Chris King - Submission Details for [REDACTED] (object)

From: [REDACTED]
 To: <chris.king@planning.nsw.gov.au>
 Date: 12/11/2012 2:43 PM
 Subject: Submission Details for [REDACTED] (object)
 CC: <assessments@planning.nsw.gov.au>

Submission for Job: #5394 SSD 5394 - 2012, Future Music Festival 2013 festival event
https://majorprojects.affinitylive.com?action=view_job&id=5394

Site: #2288 Royal Randwick Racecourse
https://majorprojects.affinitylive.com?action=view_site&id=2288

2013 Future Music Festival**TCP No. 3a (Ingress)**

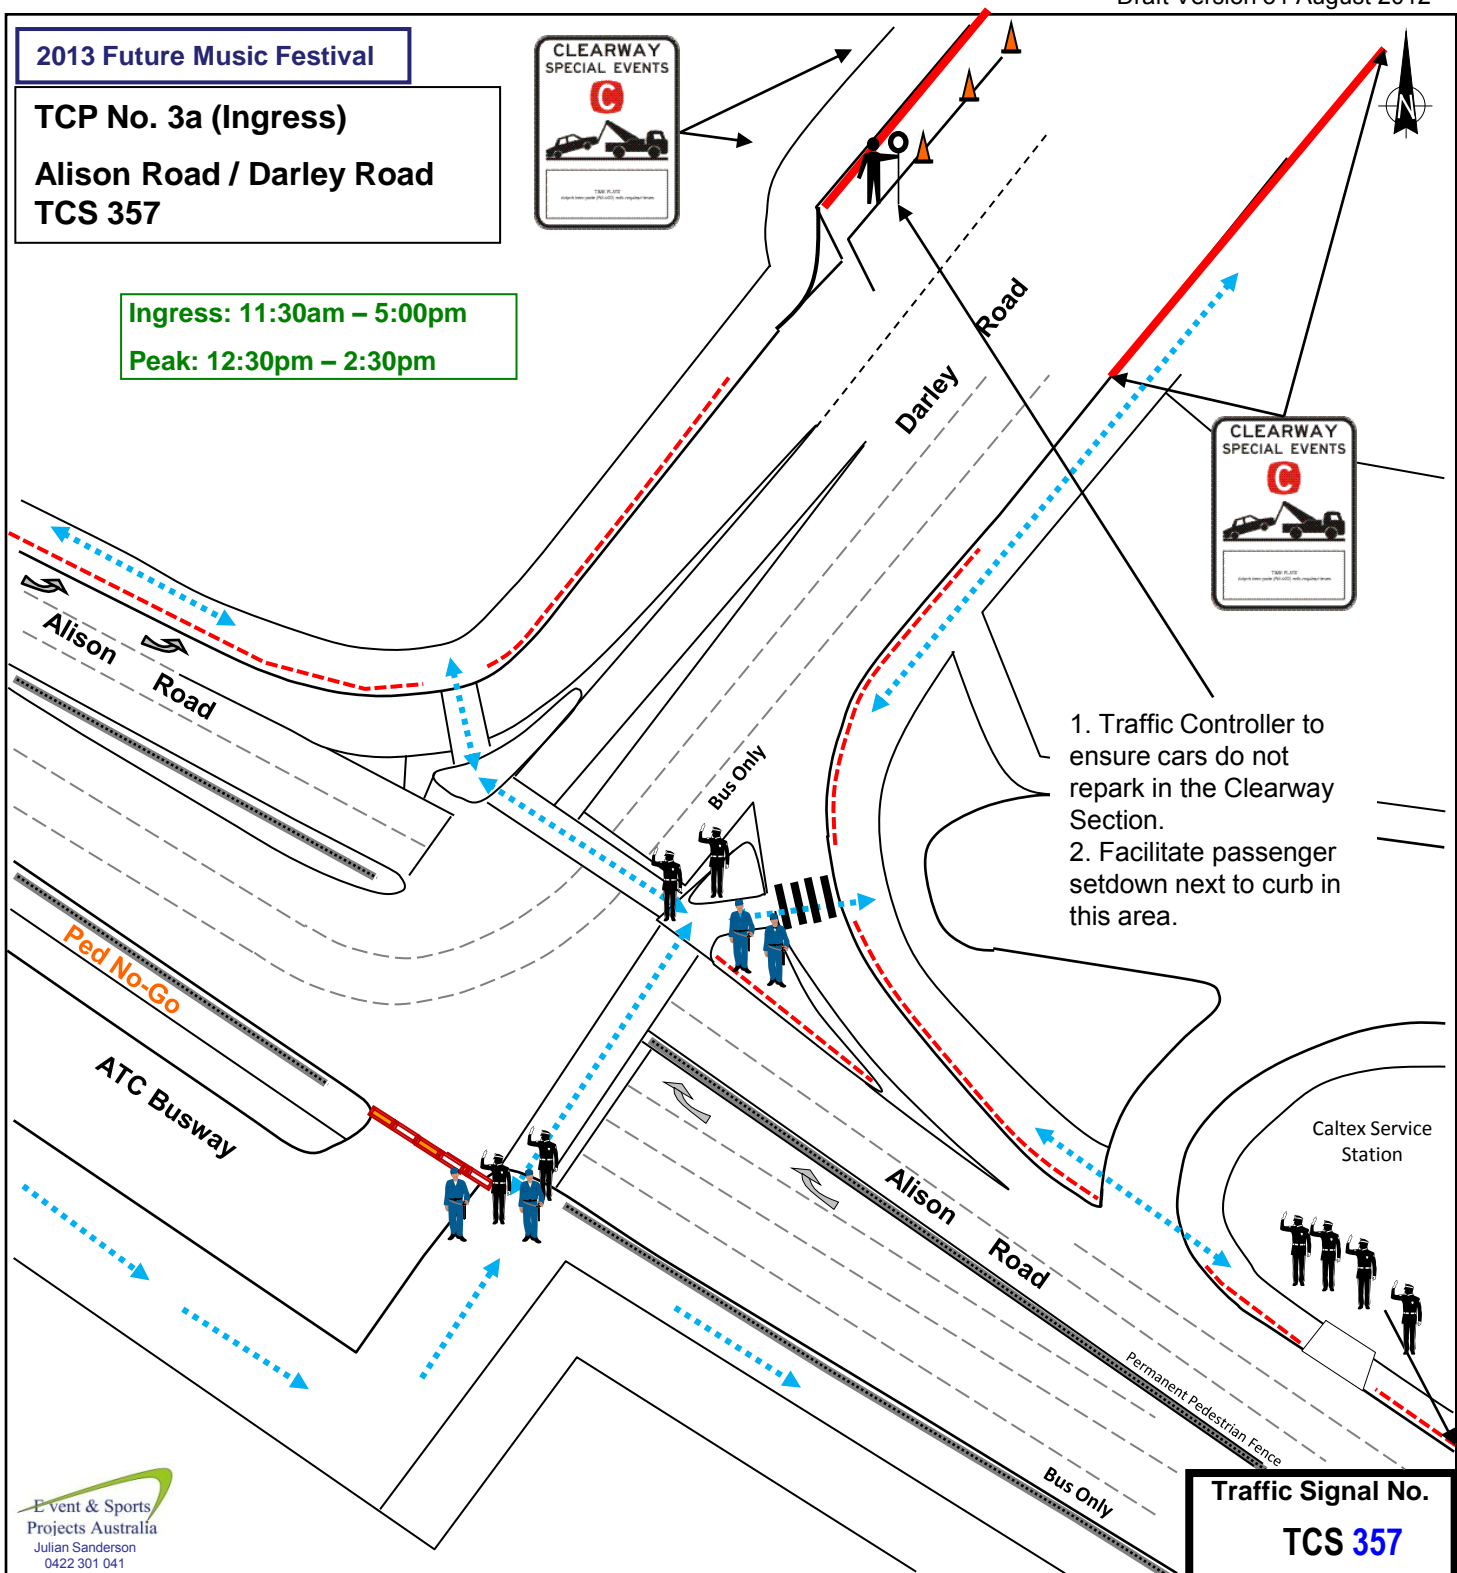
- 1) TCP 3, Alison Road / Darley Road - VMS on the centre island of Alison Road (north of Darley Road) with the message directing attendees "Free Event Parking" with a forward arrow.
- 2) TCP 4, Alison Road / John Street - needs a traffic controller restricting left hand turns from Alison Road to John Street, buses excepted, between midday and 5pm as well as a VMS on the footpath of Alison Road, south of John Street directing attendees "Free Event Parking" with a forward arrow.
- 3) TCP 5, Alison Road / Cowper Street to have a traffic controller restricting left hand turns from Alison Road to Cowper Street, buses excepted between midday and 5pm as well as a VMS on the footpath of Alison Road, north of

TCP No. 4

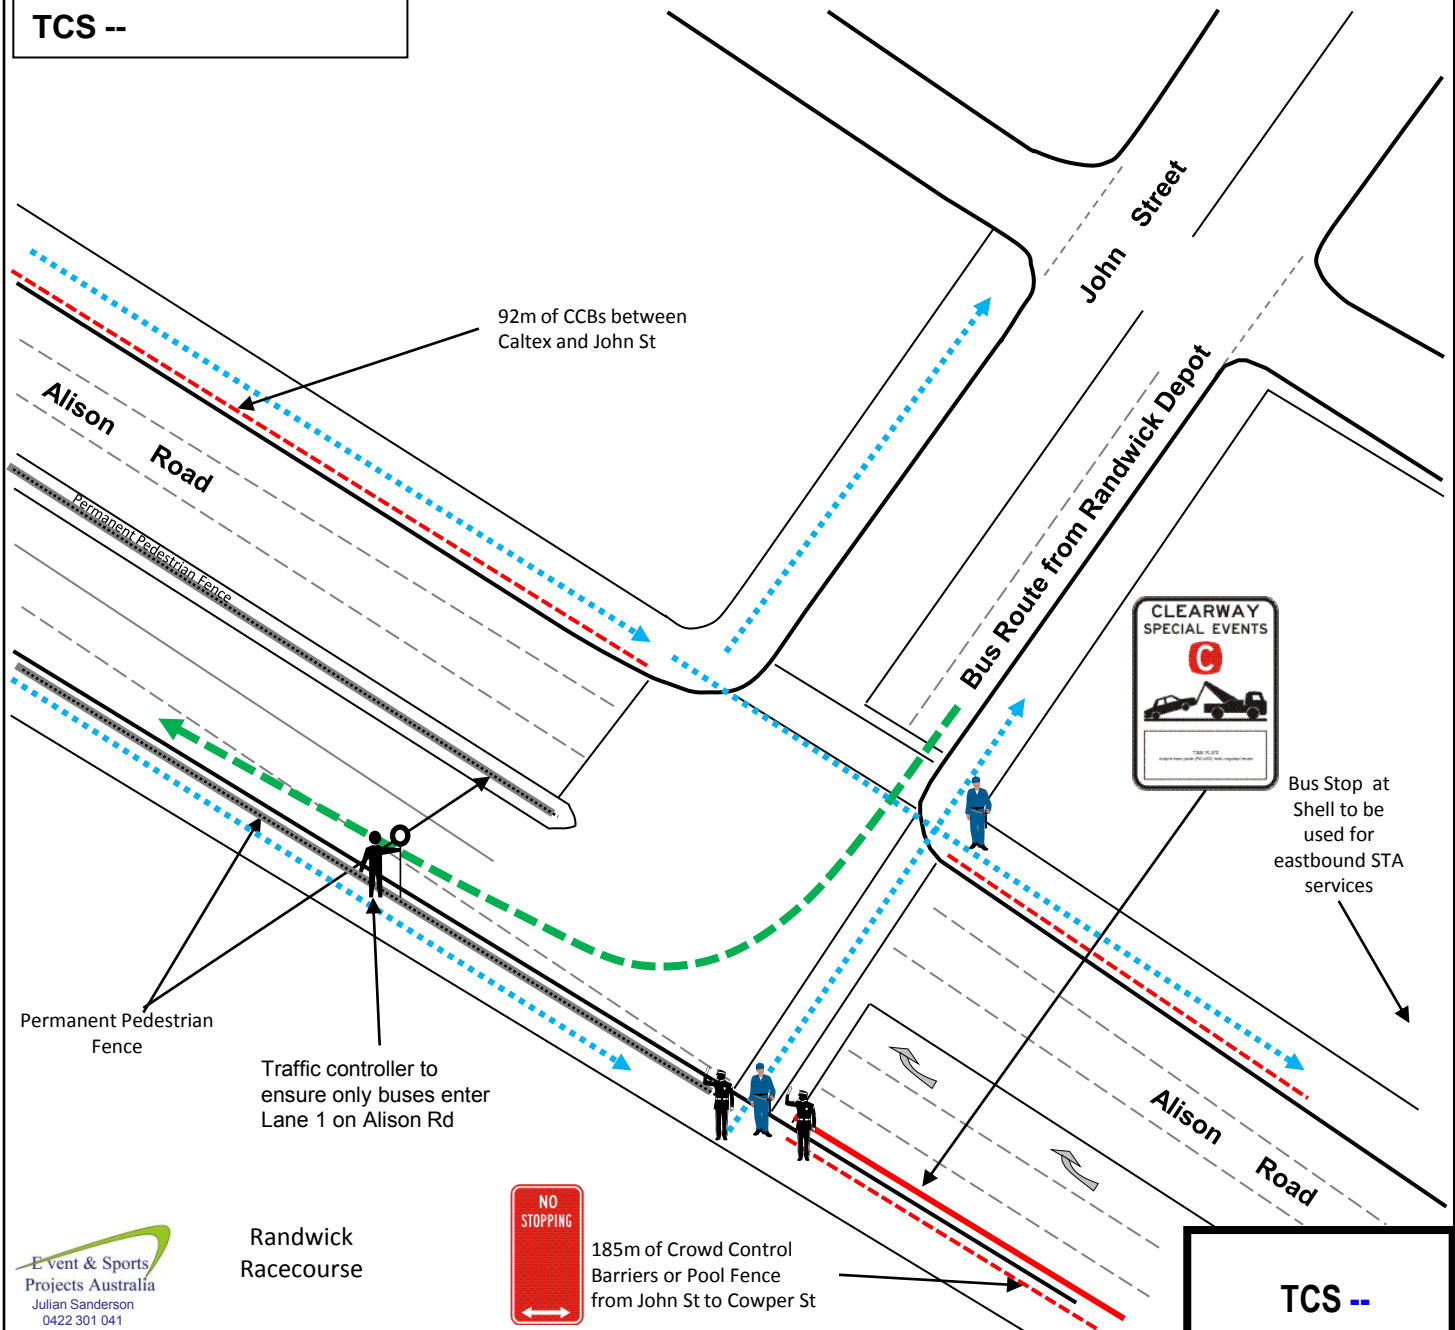
Cowper John Street directing attendees "Free Event Parking" with a forward arrow. there might be some marginal impact on through traffic on Cowper Street, but Alison Road is able to cope for displaced traffic movements eastbound, which occur in a non-peak period.

2013 Future Music Festival**TCP No. 7 (egress)**

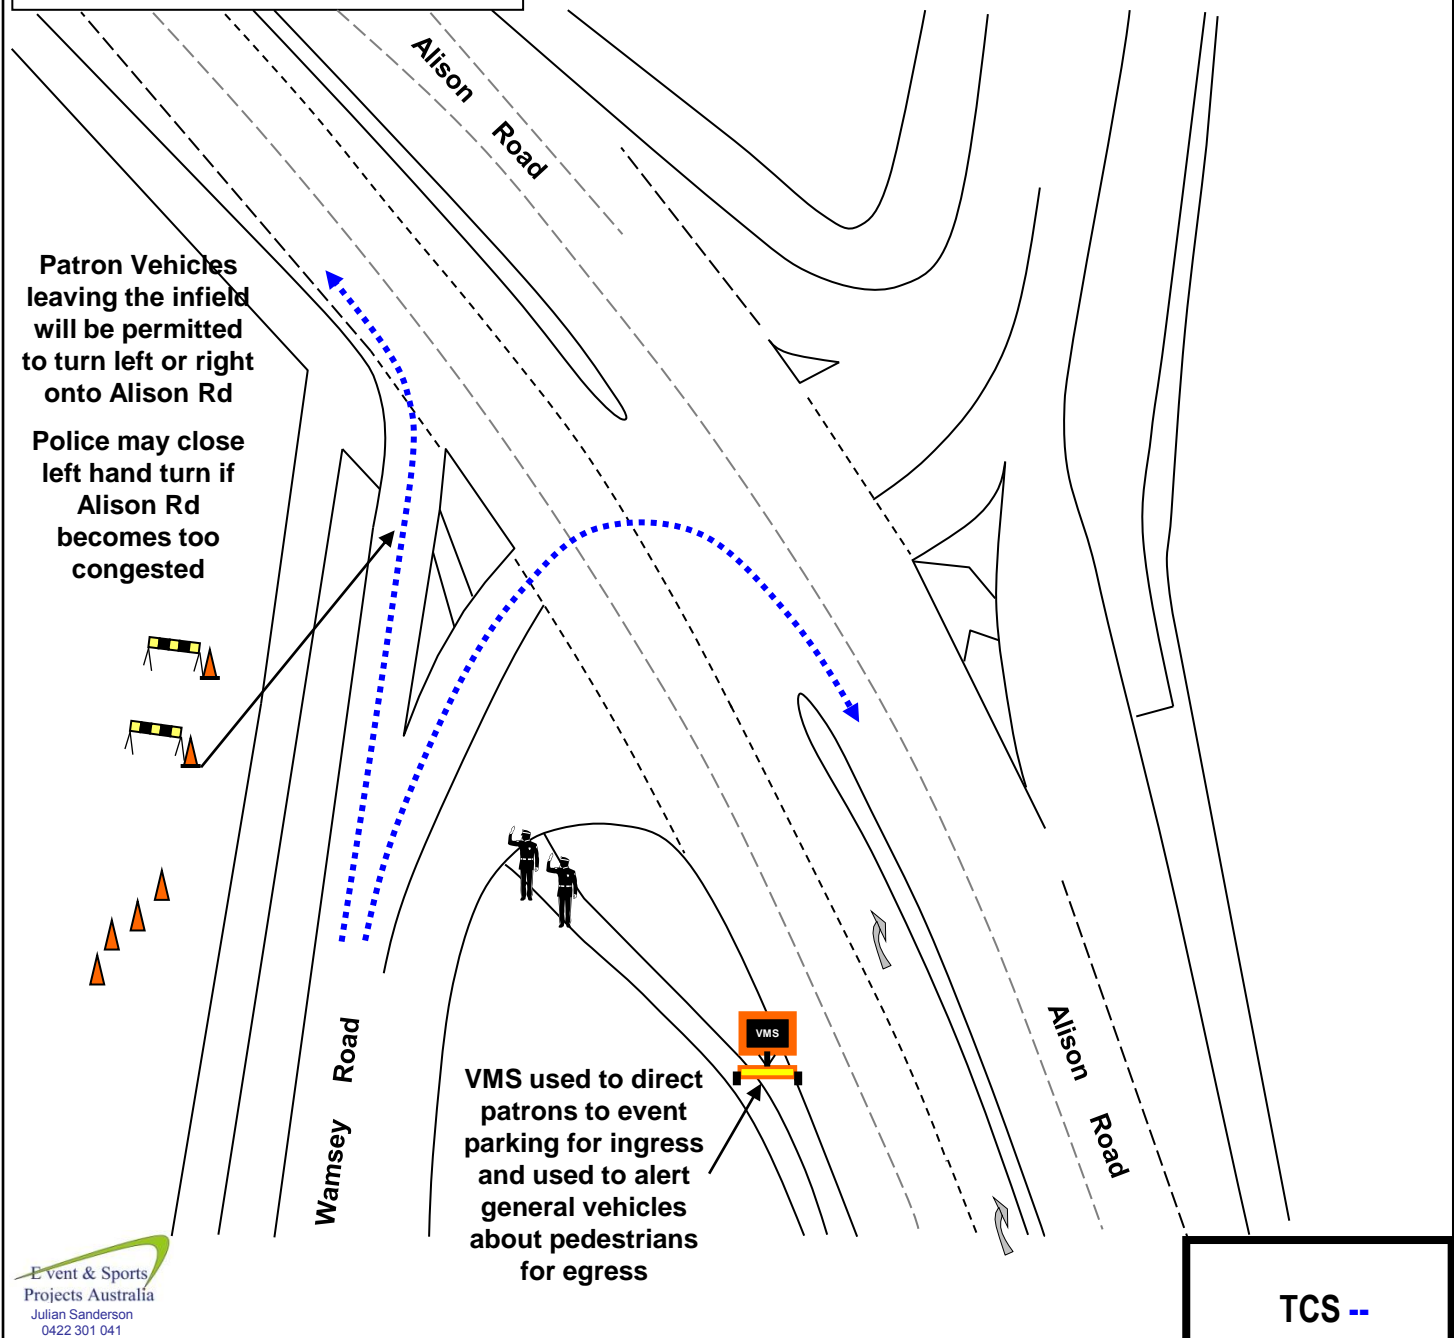
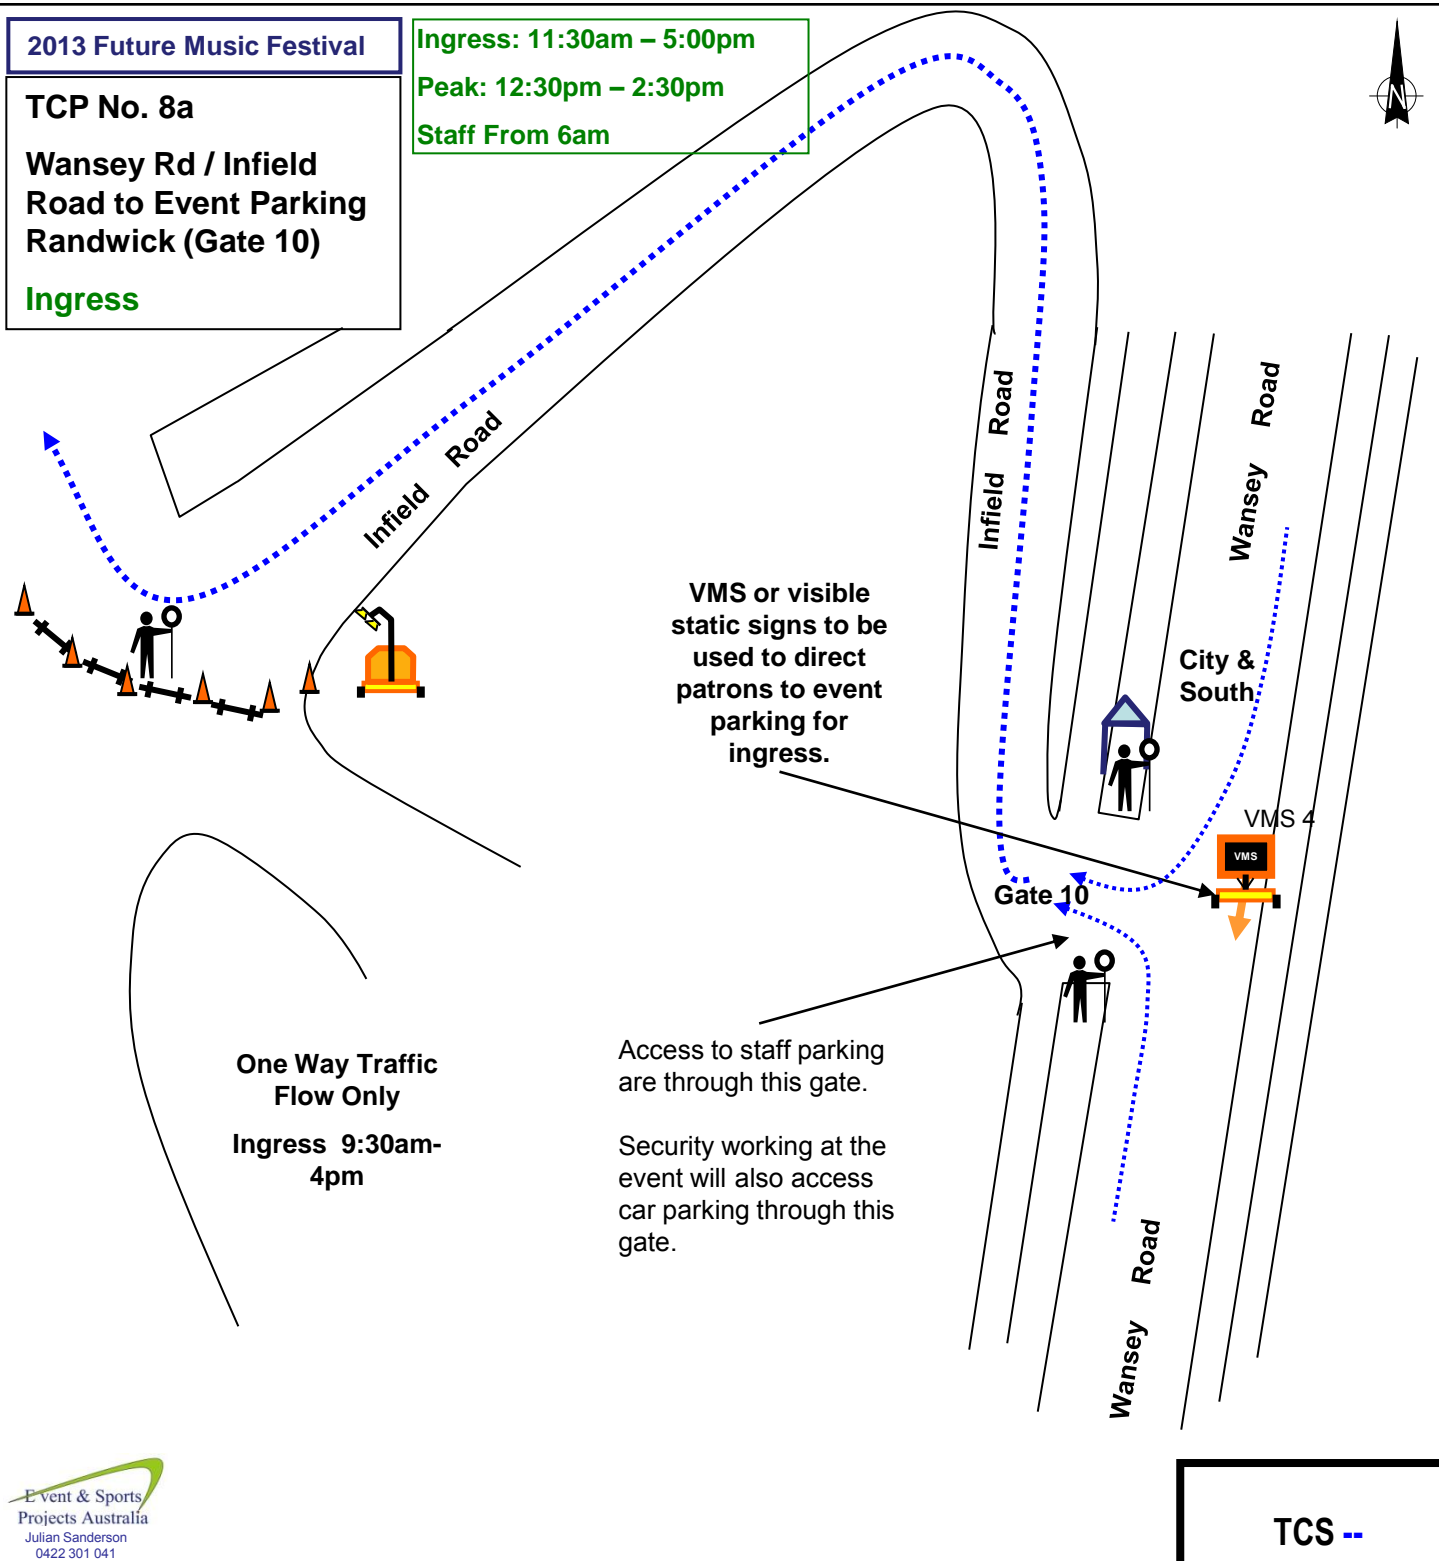
4) TCP 7, Alison Road / Wansey Avenue to have an additional VMS, suggest in the parking lane of Alison Road approximately outside #96 Alison Road directing attendees to "Free Event Parking" - with a right arrow Resident vehicle access would be via Prince Street and the 'letter to residents' distributed to the east of the Racecourse should be amended to advise of these details.
